April 17, 2018

RE: 415 Cumberland Avenue, 415 CA, LLC

Below are the responses to the Staff comments of April 3rd.

EXISTING WINDOWS TO BE REFURBISHED WHERE POSSIBLE, AND WHERE NECESSARY TO BE REPLACED WITH NEW WINDOWS TO MATCH EXISTING (NEW WINDOWS WILL BE DOUBLE GLAZED BUT WILL MATCH IN APPEARANCE)

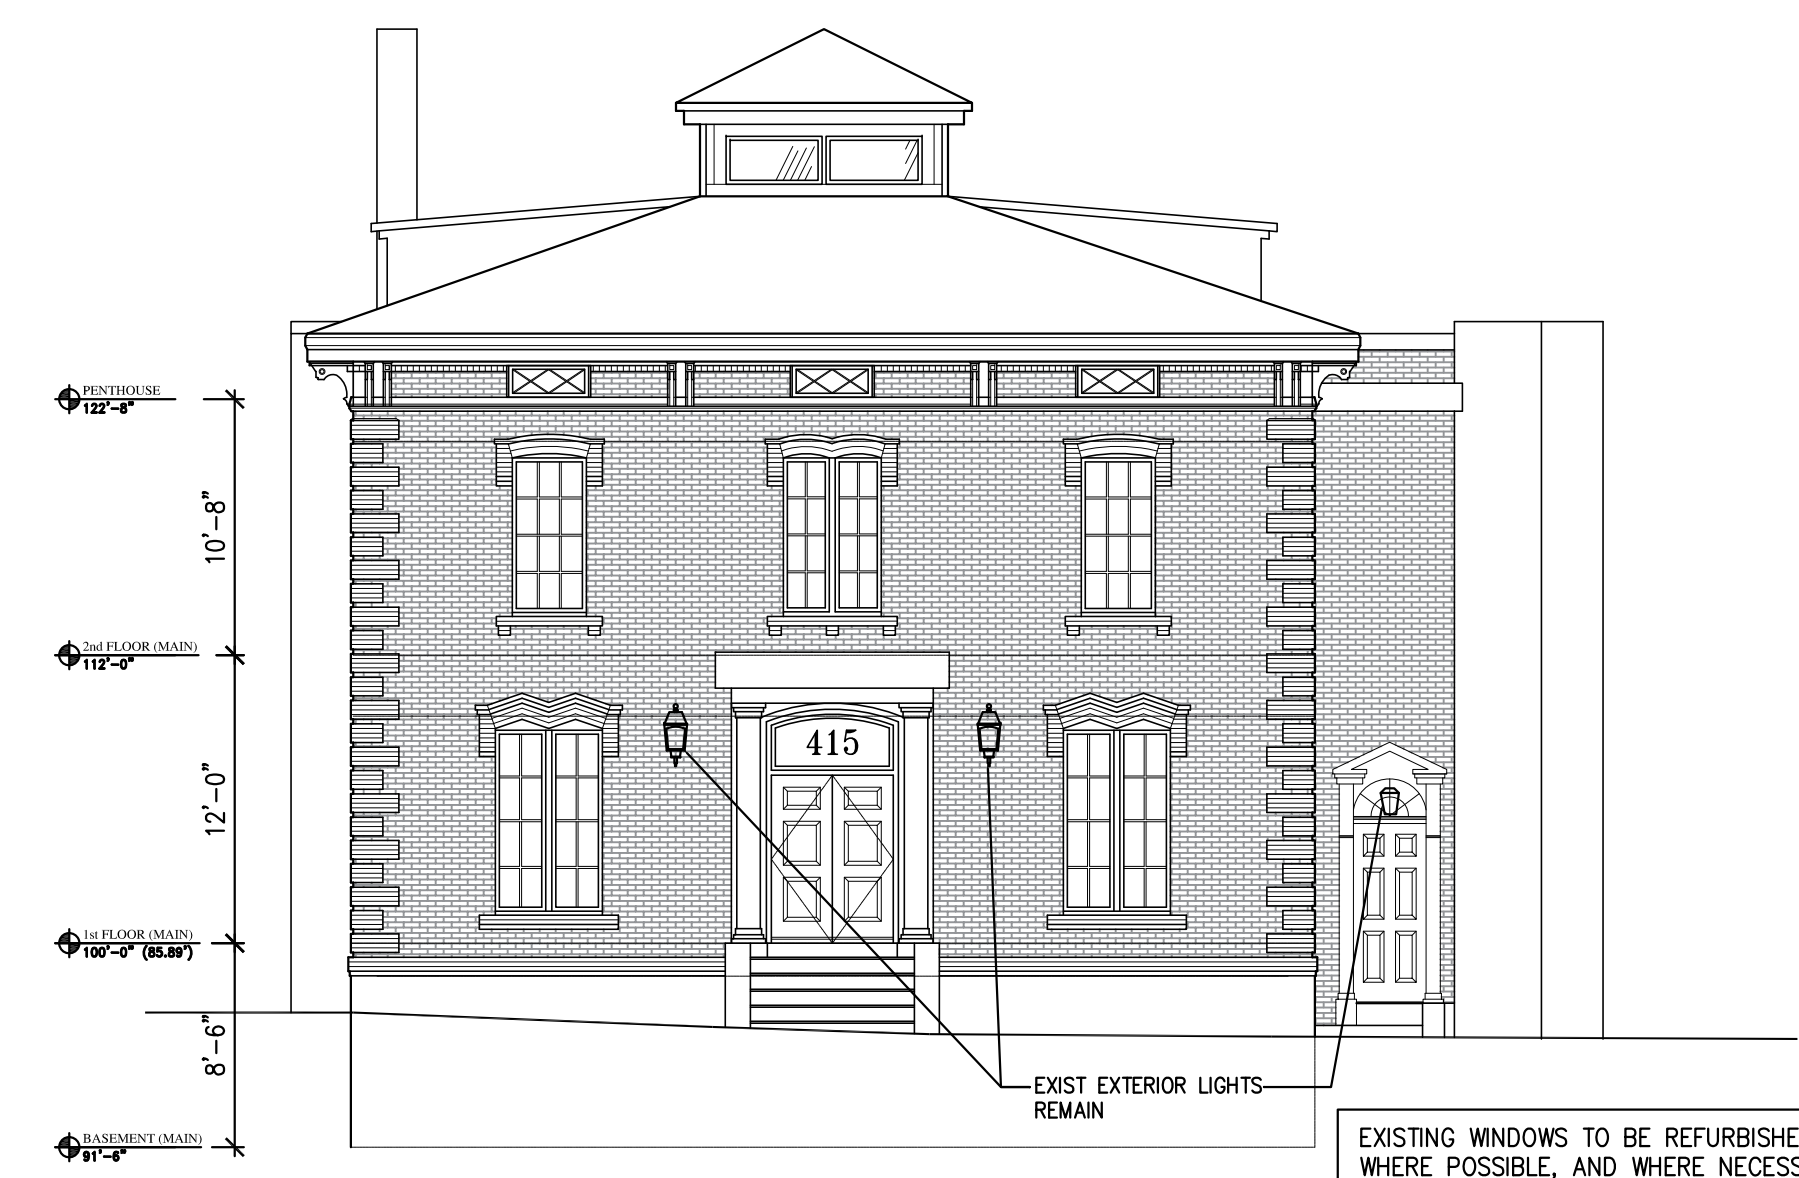
11. *Please provide details on new windows. What are the materials? Windows should feature simulated divided lites with applied exterior muntins, at a minimum. Also, please identify which windows will be repaired and which will be replaced.*

13. *Why are two windows on the northwest elevation a different height than all other windows on that elevation and the Forest Avenue elevation? Ideally these will all match.*

19. *Hardie plank at the top of the building parapets on the Forest Avenue and southwest elevations seems strange – the treatments / bands along the top of the building's middle section should be continued.*

The intent is to replace the 2nd floor windows in the brick building (residential units) and refurbish the 1st floor windows in the brick building (commercial spaces). All proposed windows in the clapboard building will be new. The revised elevations indicate which

existing windows will be refurbished and which will be replaced. The replaced windows will be aluminum clad windows with simulated divided lights. We have received quotes for replacement windows from Pella, Sierra Pacific, and Weathershield, and the replacement windows will be supplied by one of these manufacturers.

These two windows are located in kitchens and the sills are higher to allow for the kitchen counters. Currently the section of the elevation with these two windows is treated differently from the remainder of the elevation. The lower level is brick and not concrete, the gutters and rooflines are different, and there is a vertical trim board separating the two areas. We intend to maintain a trim board separating the two areas and this will mitigate the difference in sill heights.

This has been revised on the drawings to show hardie plank lap siding below the trim

and hardie panel above the trim.

**C1.2**

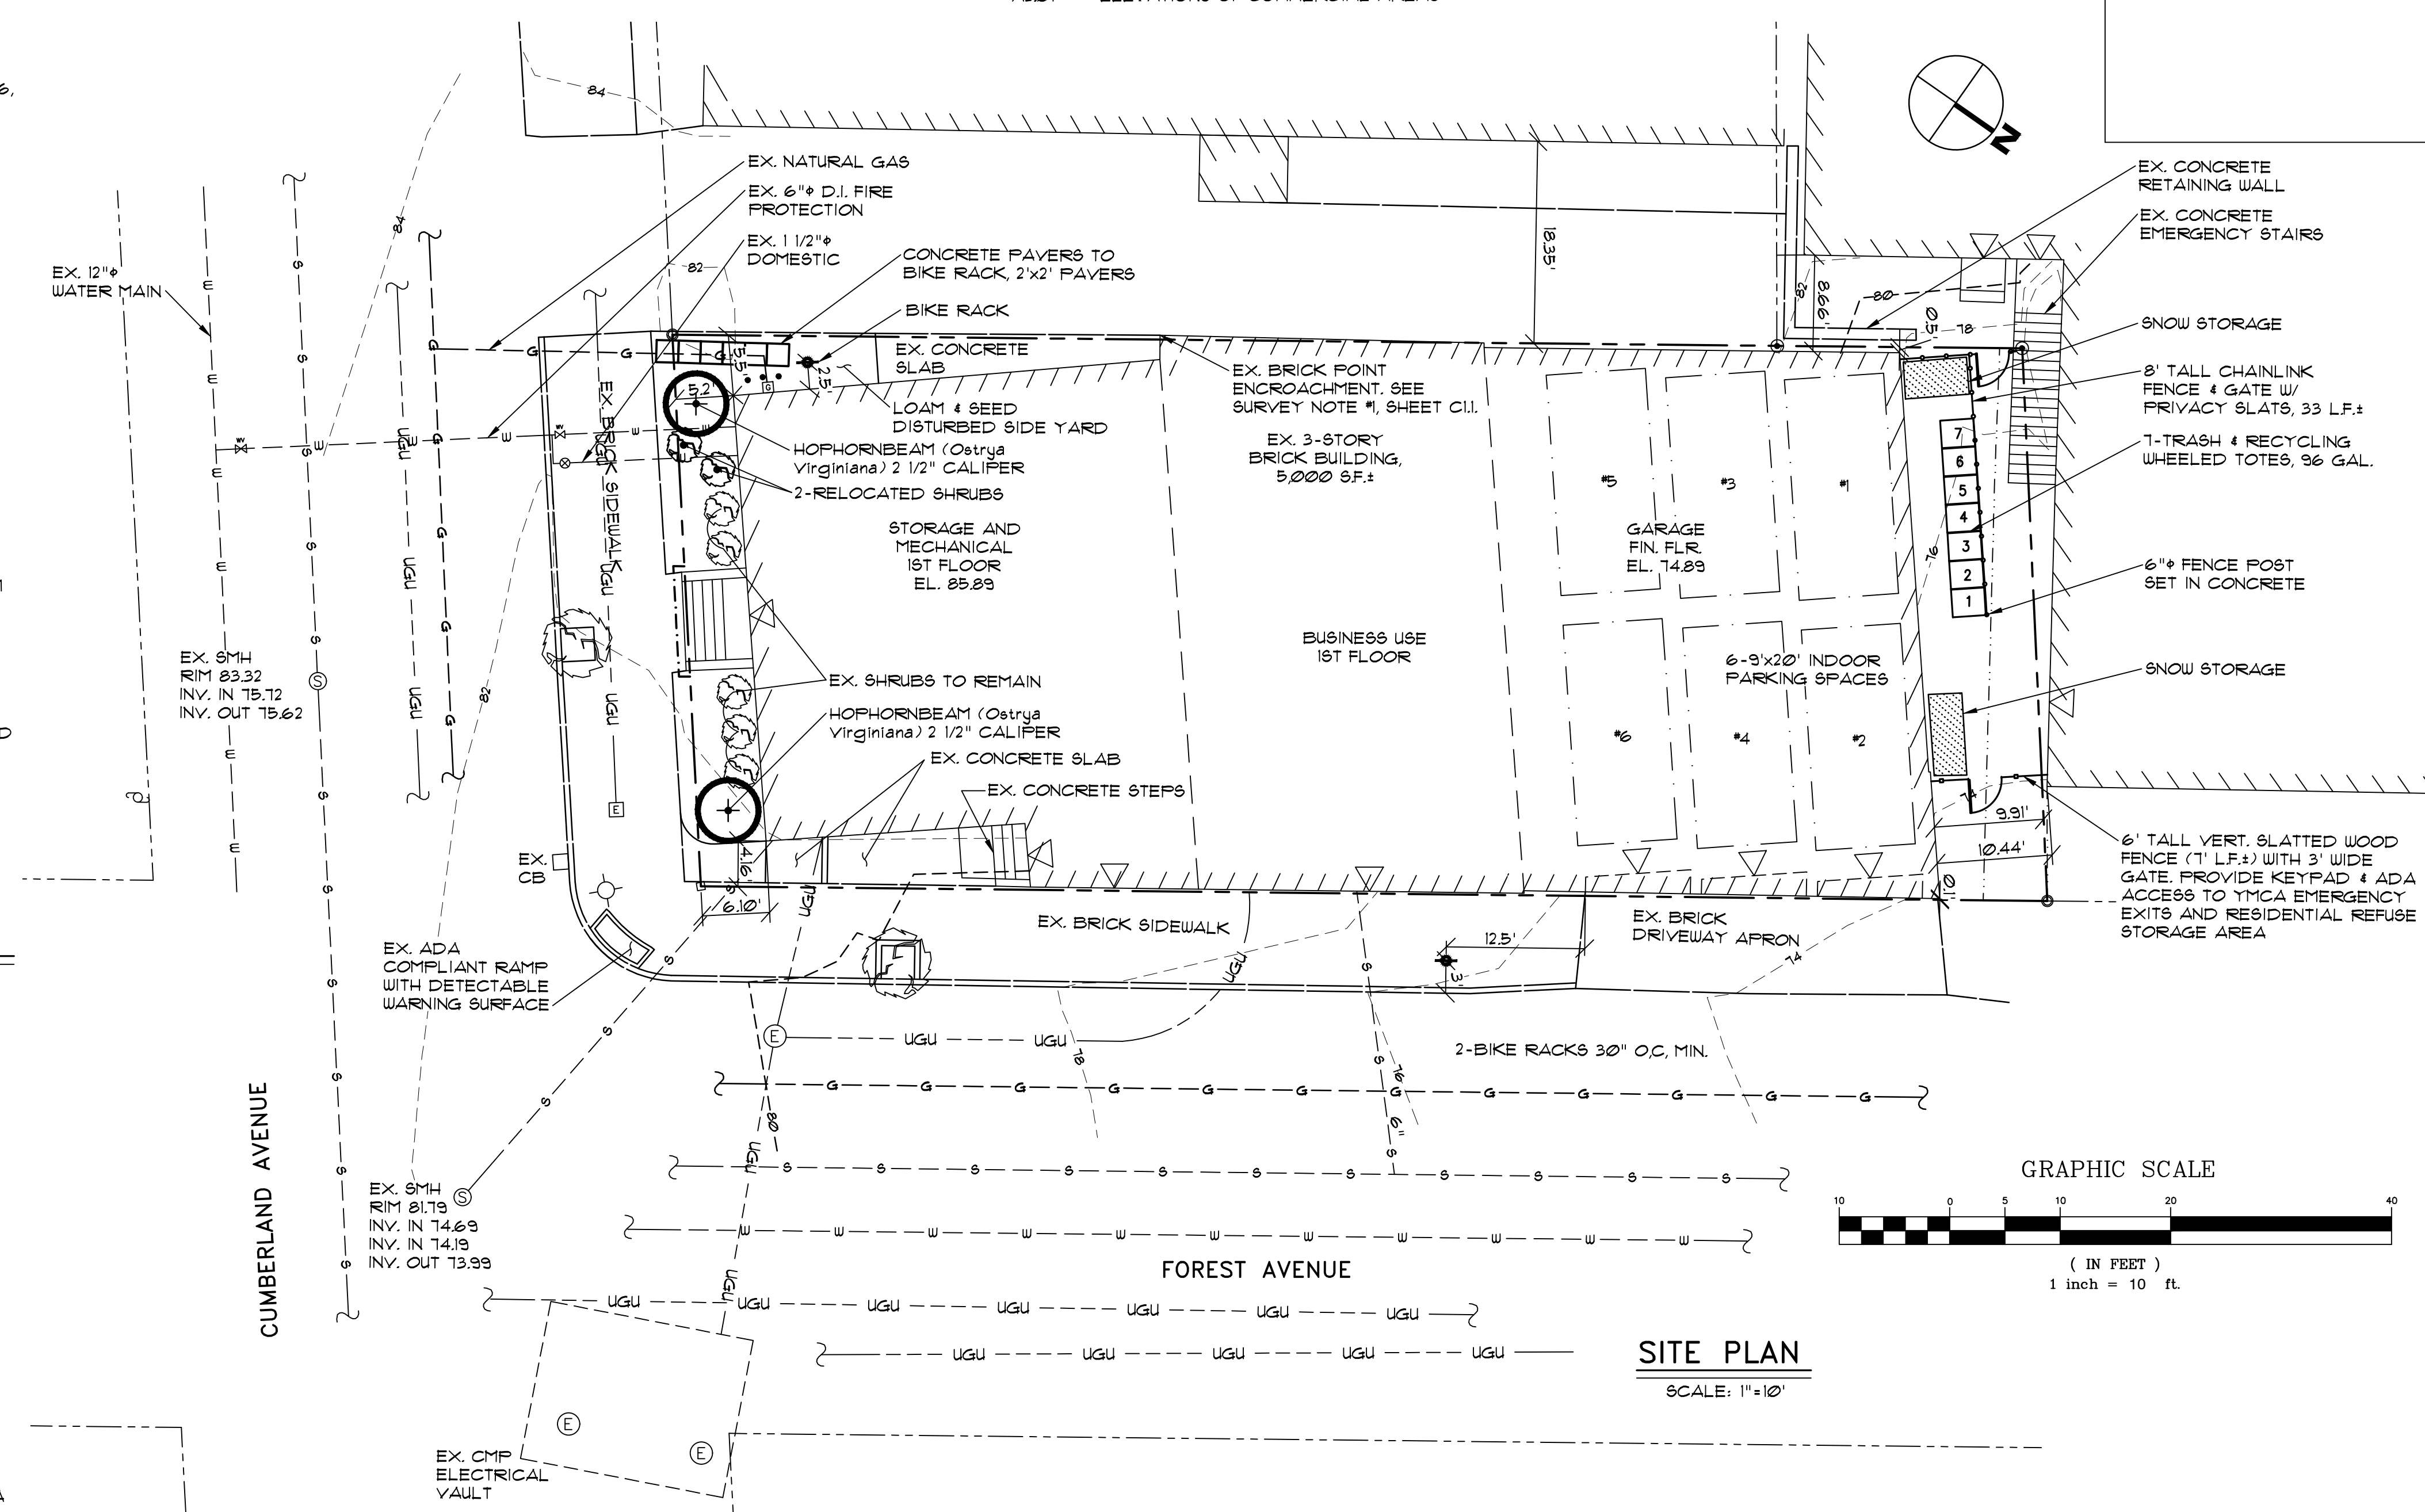
- Please provide additional information / documentation regarding the YMCA's easement on your property, as well as your plans to preserve that institution's access.*

6. *The provided survey includes half the interior parking spaces detailed on the site plan. Please ensure consistency between documents and revise.*

9. *The layout and dimensions for the two bicycle racks need to be checked for adequacy. The minimum clearance (O.C.) are: from the building, 30"; between racks, 36"; and from the edge of the driveway, 24." Sufficient clearance from the exterior gas service and bollards also must be considered. It appears the bike racks would also block access to the external stairway from the second floor without going onto the adjacent property. Other bicycle rack locations on-site or within the sidewalk on either Forest and / or Cumberland Avenue can also be considered to make them more functional and not block this access.*

The easement has been uploaded for your review. Please note the gate will be keypad operated and compliant with ADA Standards as noted on C1.2.
- The content of the landscaping plan uploaded in January does not match the landscaping identified on the Site Plan uploaded in March. Please revise and ensure consistency between the two documents.*

The survey has been revised.

The bicycle racks have been revised. One is located on Forest Avenue and one off Cumberland Avenue.
